Preferred Project Report Project Application

Albert Avenue and Thomas Street, Chatswood
Mixed Use Development (MP09_0066)

Submitted to
Department of Planning
On Behalf of Welles Thomas Pty Ltd

July 2010 ■ 09141

**1** GROUND FLOOR PLAN  
1:200

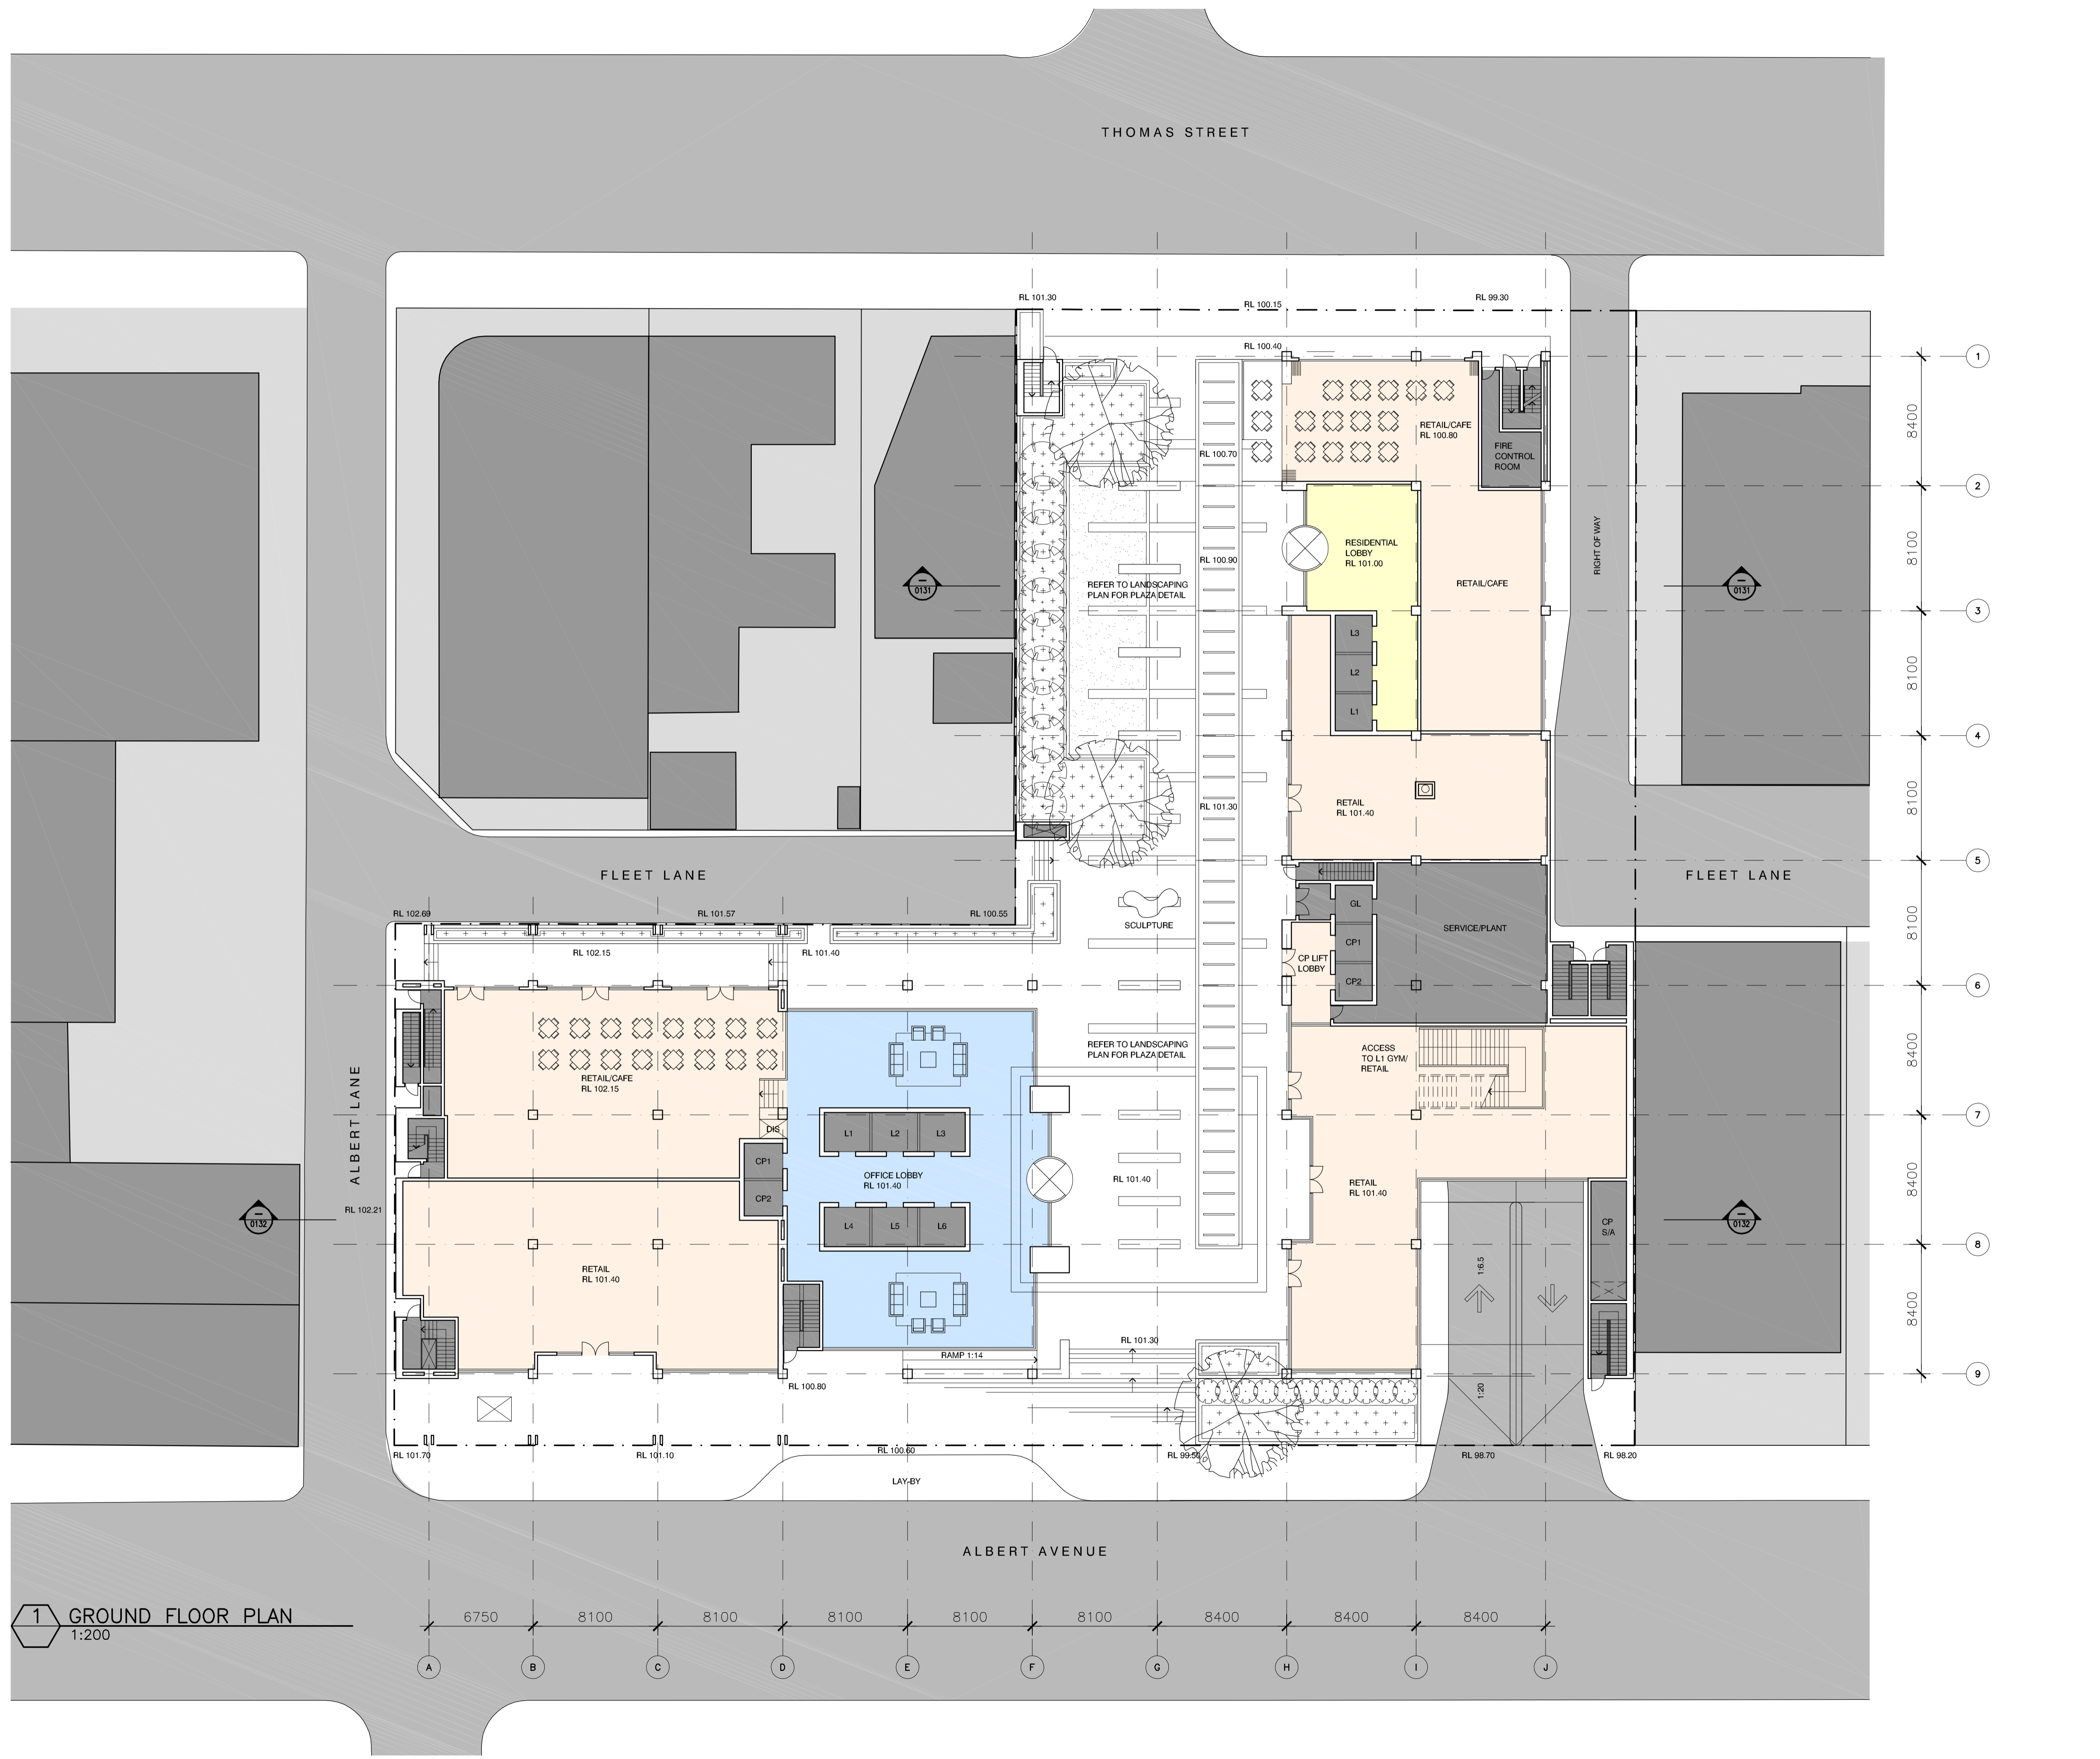
Both the RTA and Council noted the need for an additional vehicle exit at the Thomas Street frontage. At the meeting with the Department on 6 May 2010, the applicant and its consultants discussed the possibility of removing the right-of-way from Fleet Lane and providing an exit ramp in this location. The Department indicated that input from Council would be needed on this issue.

- A right-of-way from Fleet Lane and exit ramp from Basement 1 to be provided to Thomas Street; and
- The width of both the right-of way and exit ramp should be kept to a minimum on the Thomas Street frontage i.e. 6 to 8 metres total.

PTW have prepared a revised Ground Floor and Basement 1 sketch which demonstrate the revised vehicle access arrangements (see **Appendix B**). It is proposed that the attached sketch be approved as part of the Project Application approval for the project. The Draft Statement of Commitments has been amended which states that full documentation of the revised scheme will be submitted to the Department following approval of the Project Application (see Section 9.0 below).

BASEMENT 1 PLAN

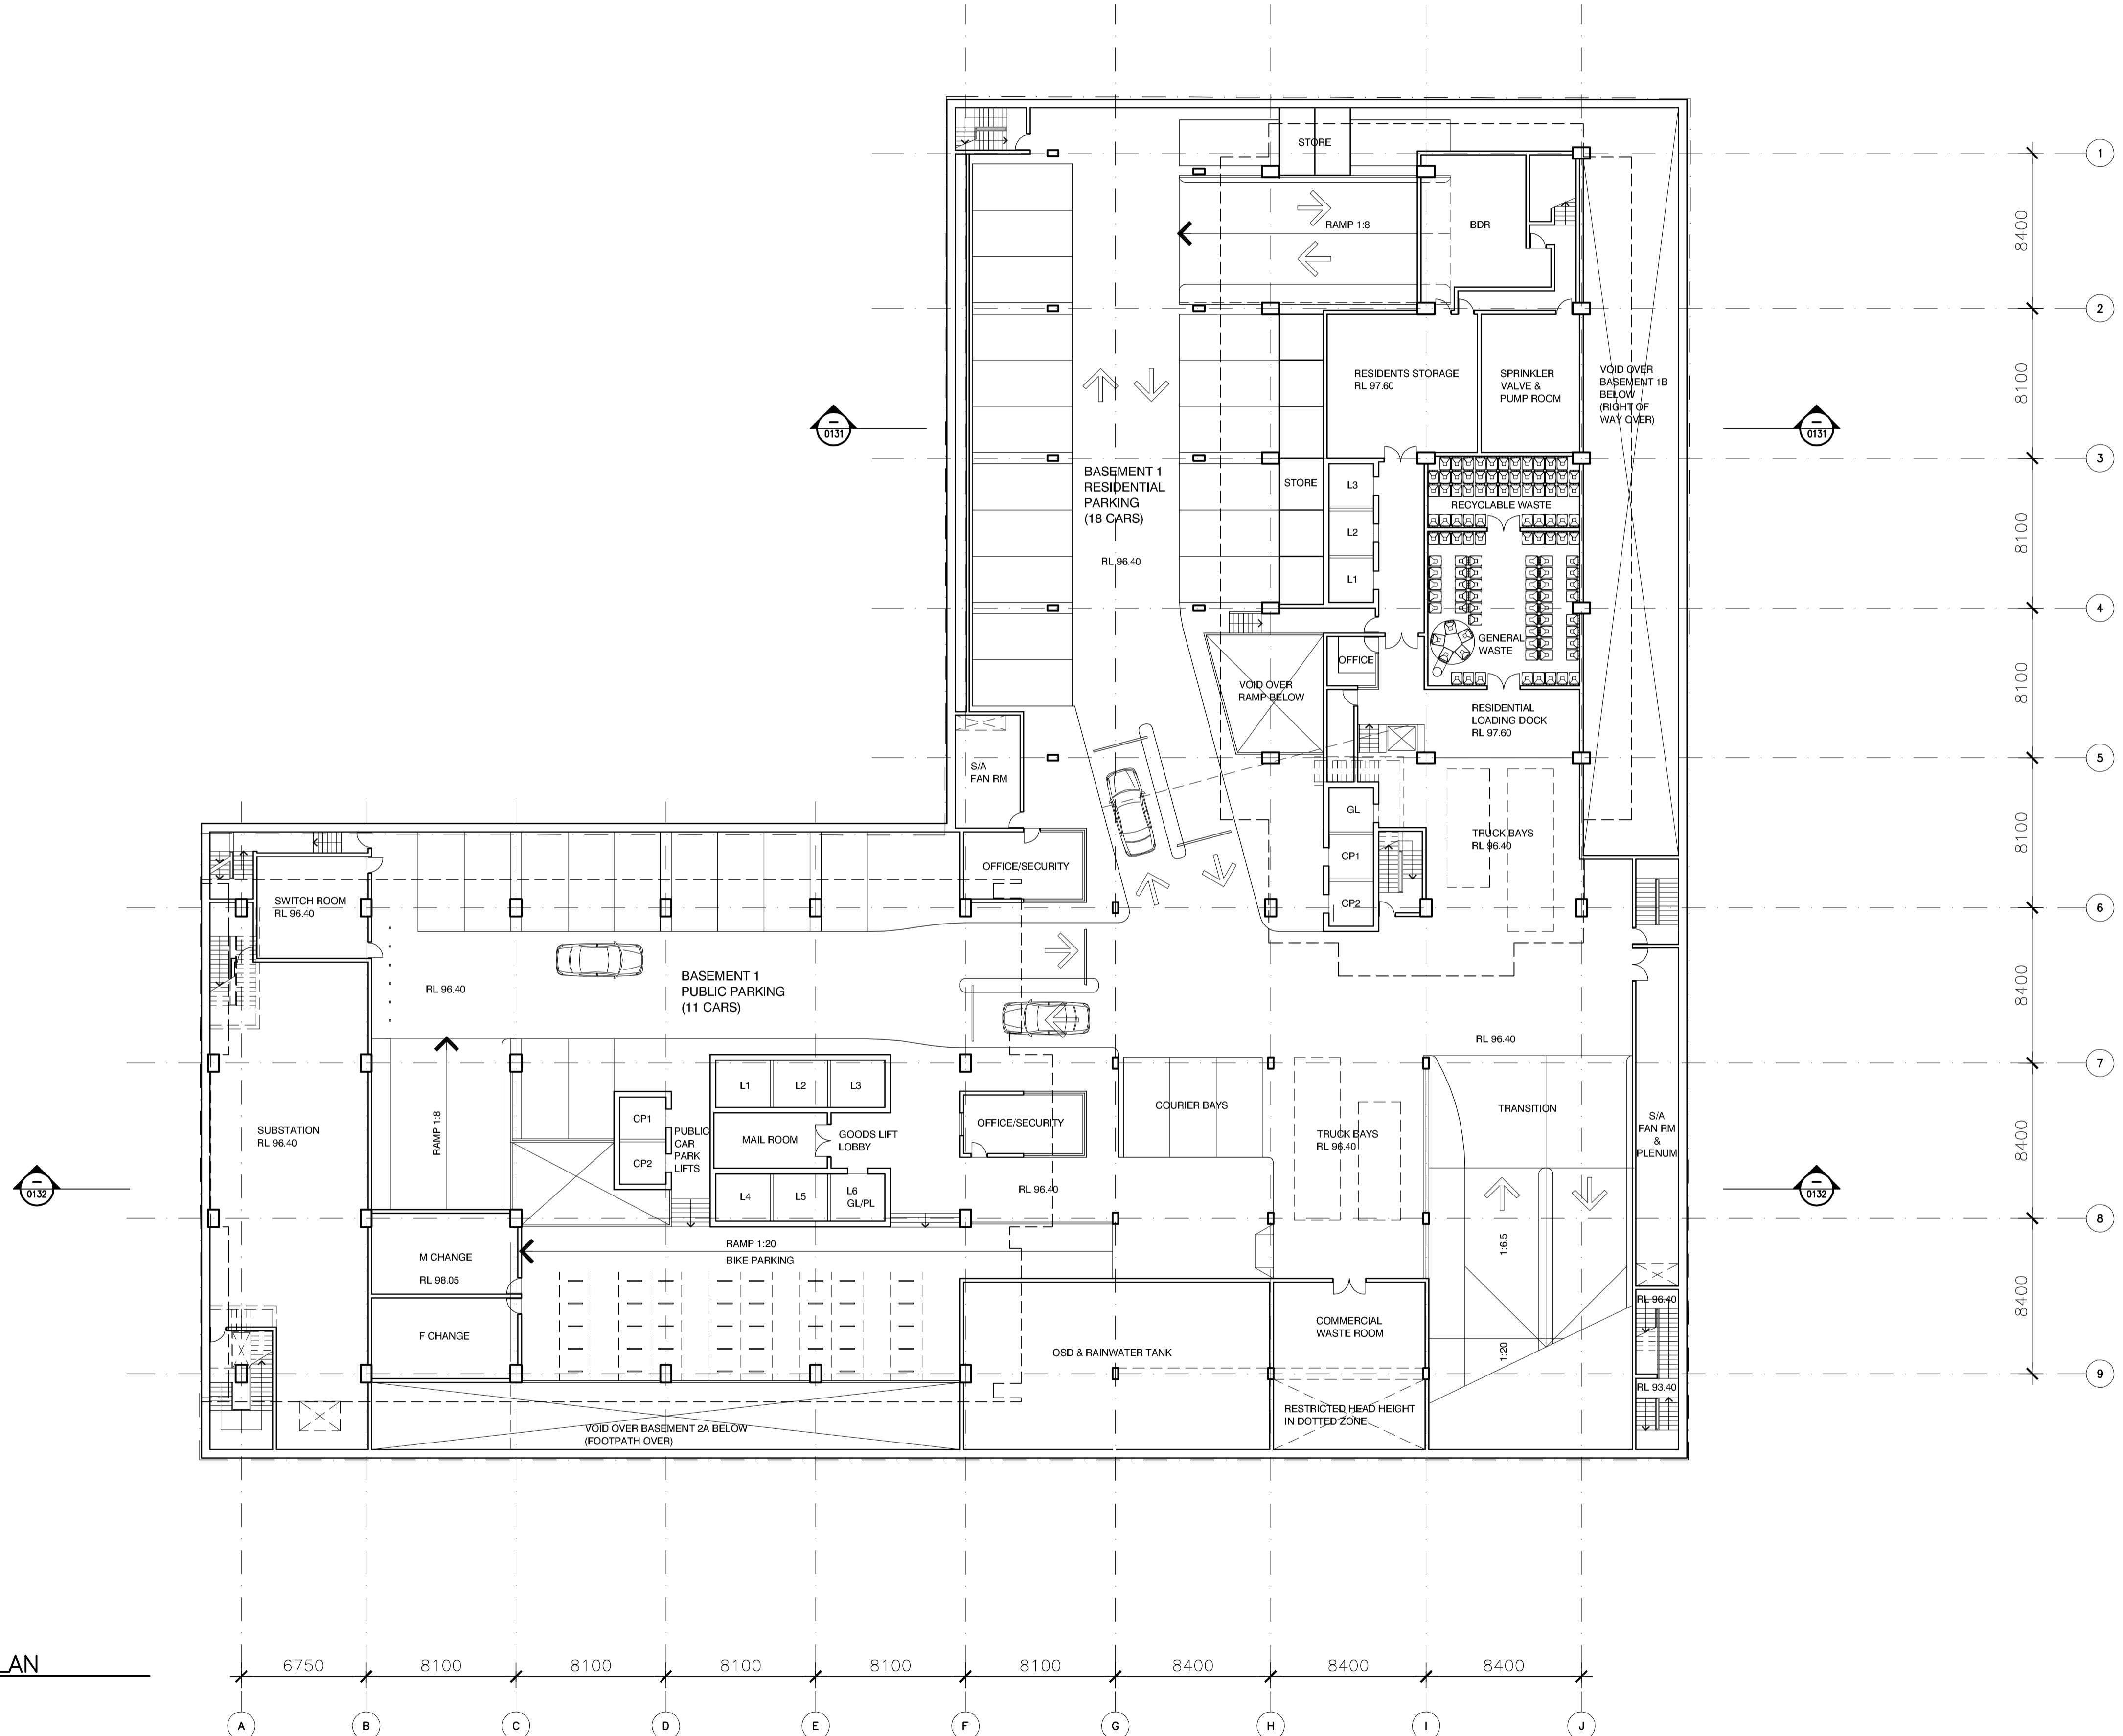
At the meeting between PTW and Council on 13 May 2010, Council indicated that it would prefer to have both the right-of-way and an exit ramp provided in this location (ie. at the frontage to Thomas Street). The following in-principle agreements were reached with Council's planning staff:
